**Your ref:**  
**Our ref:** 21/11053/PREP  
**Enquiries to:** Mrs Karen Timms  
**E-mail:**  
karen.timms@eastriding.gov.uk  
**Telephone:** (01482) 393877  
**Date:** 11 October 2021

| <b>Proposal:</b>         | Proposed erection of a single storey building to be used as annexe living accommodation to main dwelling following demolition of existing outbuilding |
| <b>Location:</b>         | Beckside, 63 London Street, Pocklington, East Riding Of Yorkshire, YO42 2JW,  |
| <b>Application Type:</b> | Pre Application Planning Enquiry  |

Proposed Ground Floor Plan

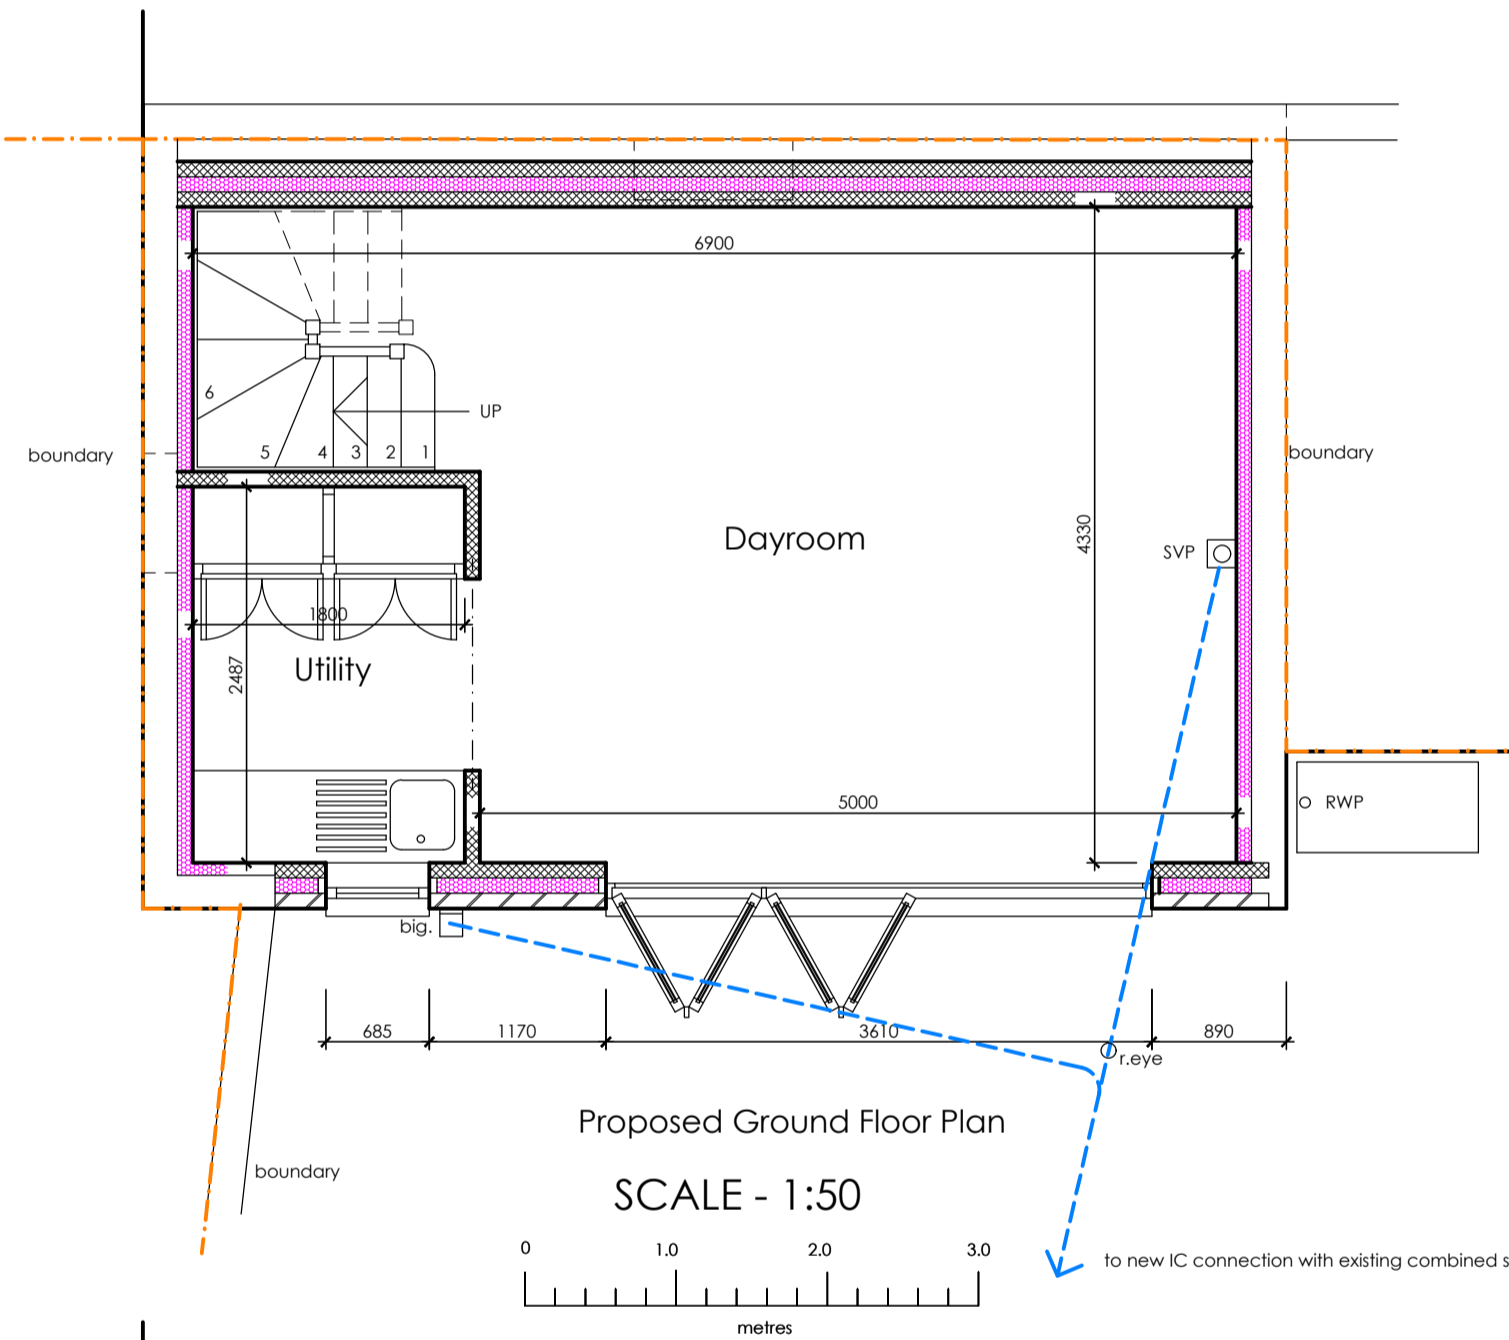
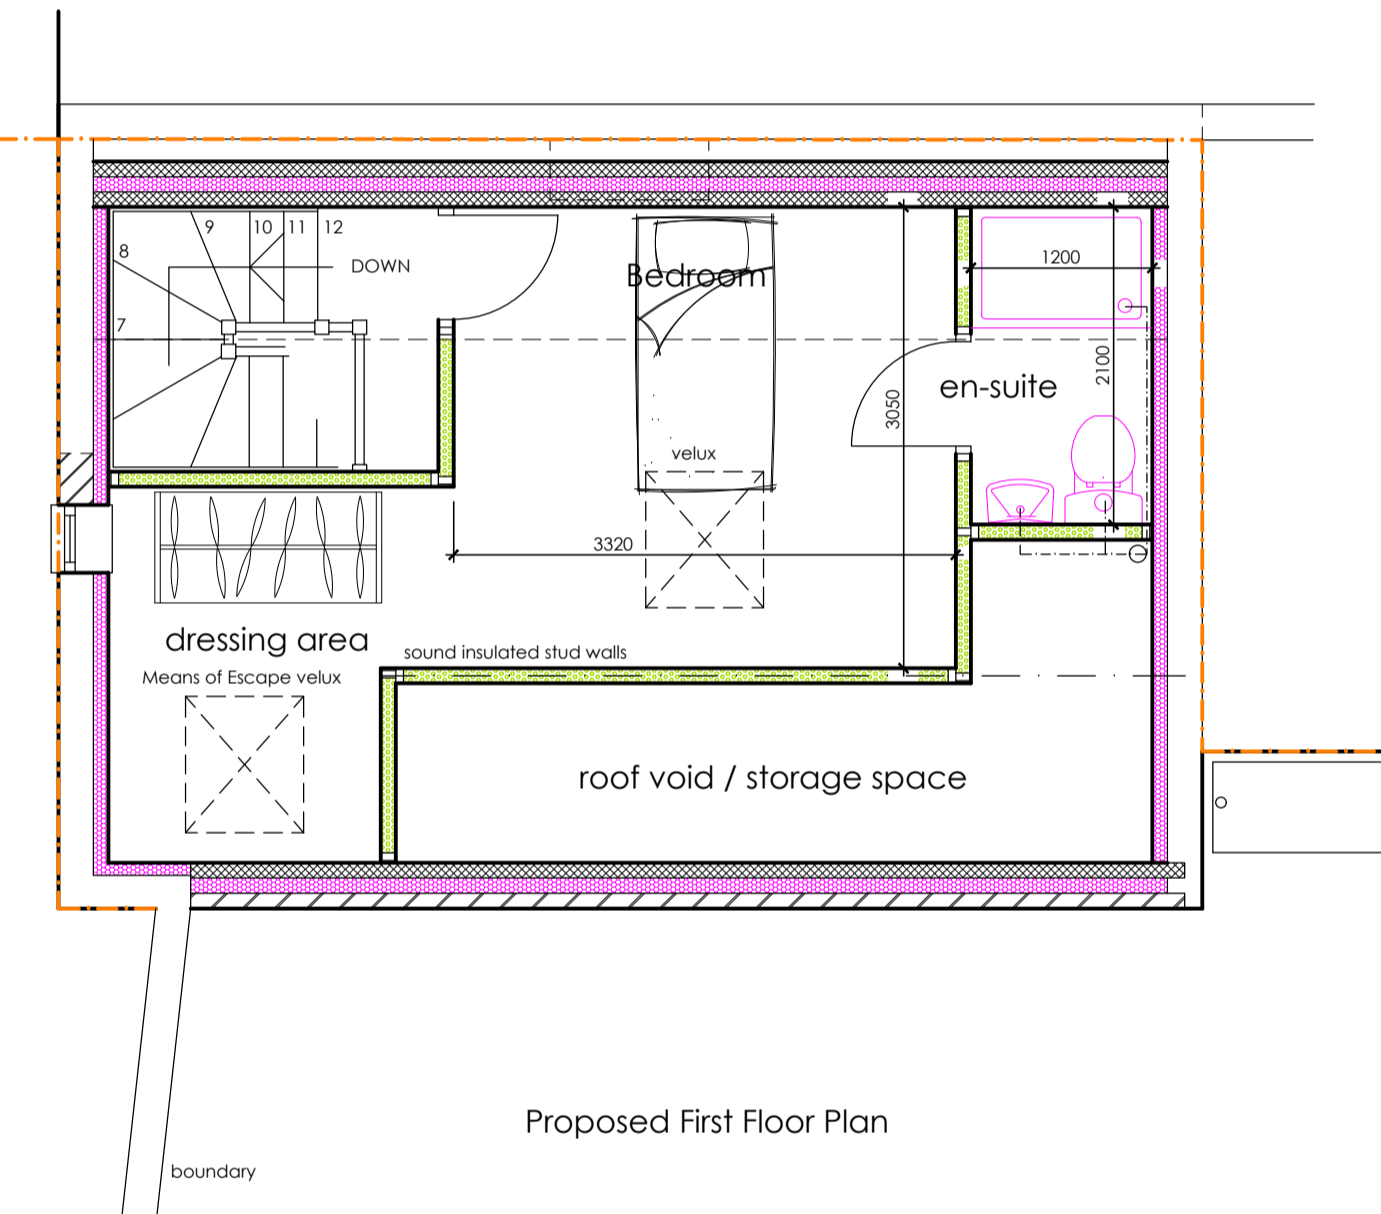
The information submitted as part of the enquiry is limited and therefore I can only give advice based on the principle of an annexe in this location. It is not clear if the annexe would be fully self-contained or if it would share some facilities with the main dwelling. If the internal layout of the building indicated that it did not contain all facilities that would make it capable of independent occupation, such as a shared kitchen with the main dwelling then the proposed development could be dealt with under an application for householder development (current fee £206), though it would still be beneficial to provide supporting information within any application that the accommodation would remain ancillary to the existing dwelling for the purposes as you have indicated.
